## Jeanie Bourke - Re: 71 Quebec Street - Exterior stair

**From:** Jeanie Bourke  
**To:** Richard Lo  
**Date:** 10/15/2015 1:51 PM  
**Subject:** Re: 71 Quebec Street - Exterior stair  
**CC:** Phil Kaplan

The house at 71 Quebec Street is nearing completion. We have a question regarding the handrail & guard requirements for the exterior stair from the 2nd floor deck down to the rear garden.

3 NORTH-WEST (REAR ELEVATION)
SCALE: 1/8" = 1'-0"

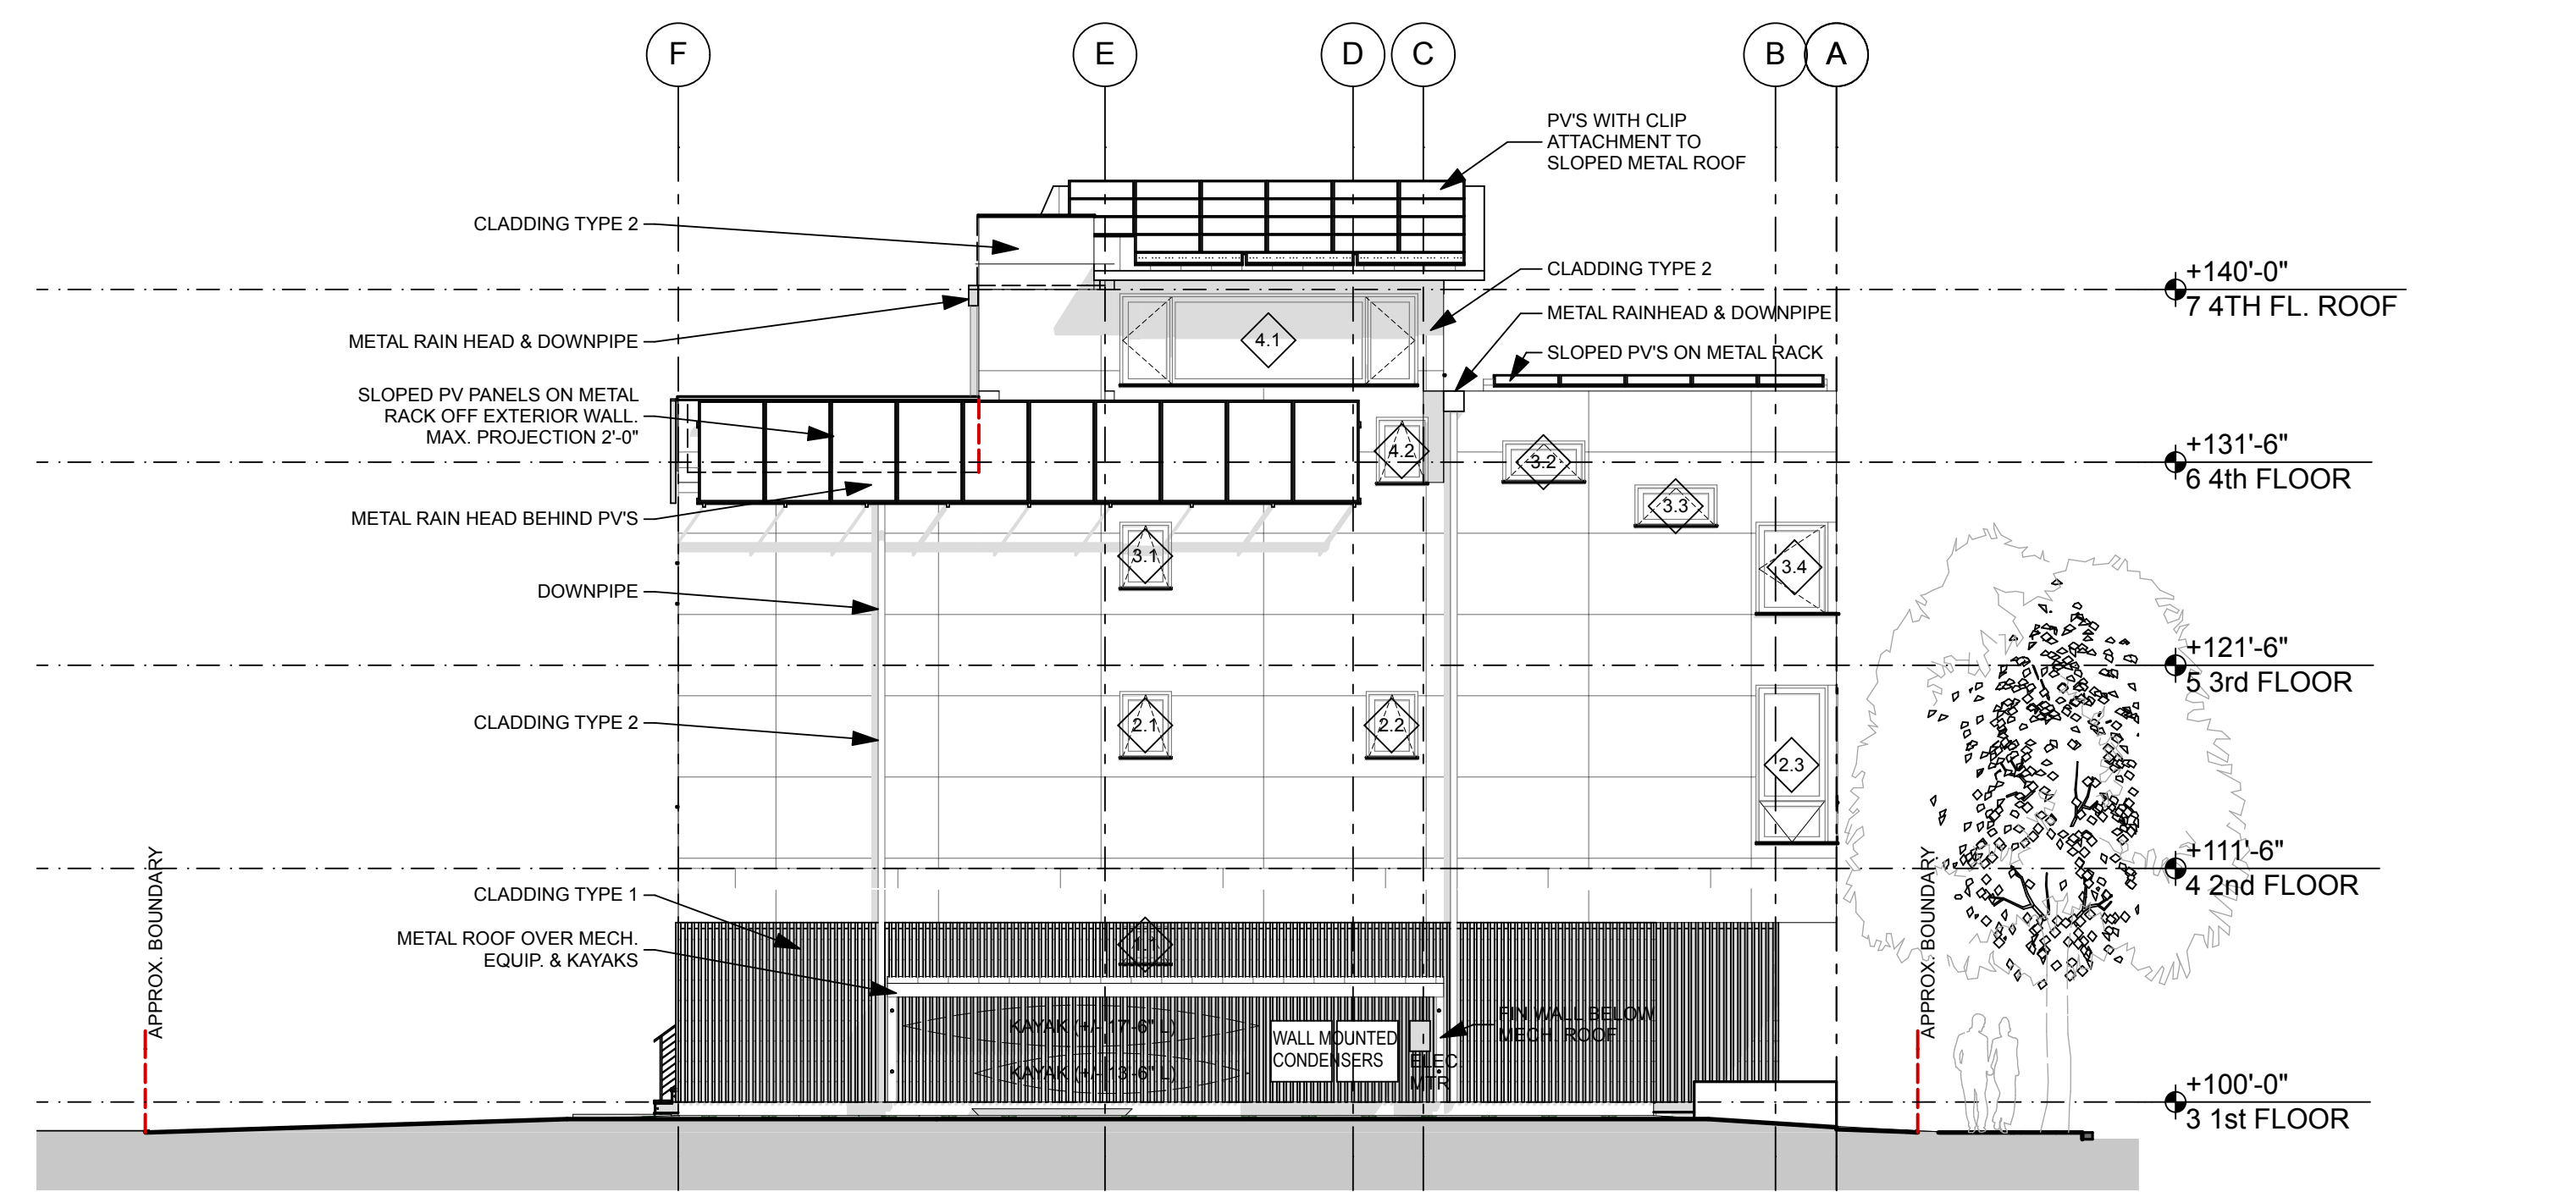
- Handrail on only one side of the stair permitted (IBC 1009.12 exception 2).
- Handrail extensions at top & bottom of stair not required (IBC 1012.6 exception 1).
- Openings in stair guards to be 4 3/8" max (IBC 1013.3 exception 6).

We believe the exterior stair at Quebec Street may be considered to be "within the dwelling unit", as it is clearly part of a "dwelling", & entirely within the dwelling project (providing private access between the 2nd floor deck & the rear garden of the same dwelling). Other considerations are that the same handrail & guard exceptions apply to interior stairs on the same project, including stairs up to the 4th floor.

Can you please provide a confirmation that you would also consider the exterior stair to be "within the dwelling"?

In my judgement, the intent of these code references is for R-3 uses of child or adult care facilities, and not single family homes such as this property. As such, I am confirming that the exterior stair is allowed to have 1 handrail, openings of less than 4-3/8", and no handrail extensions.
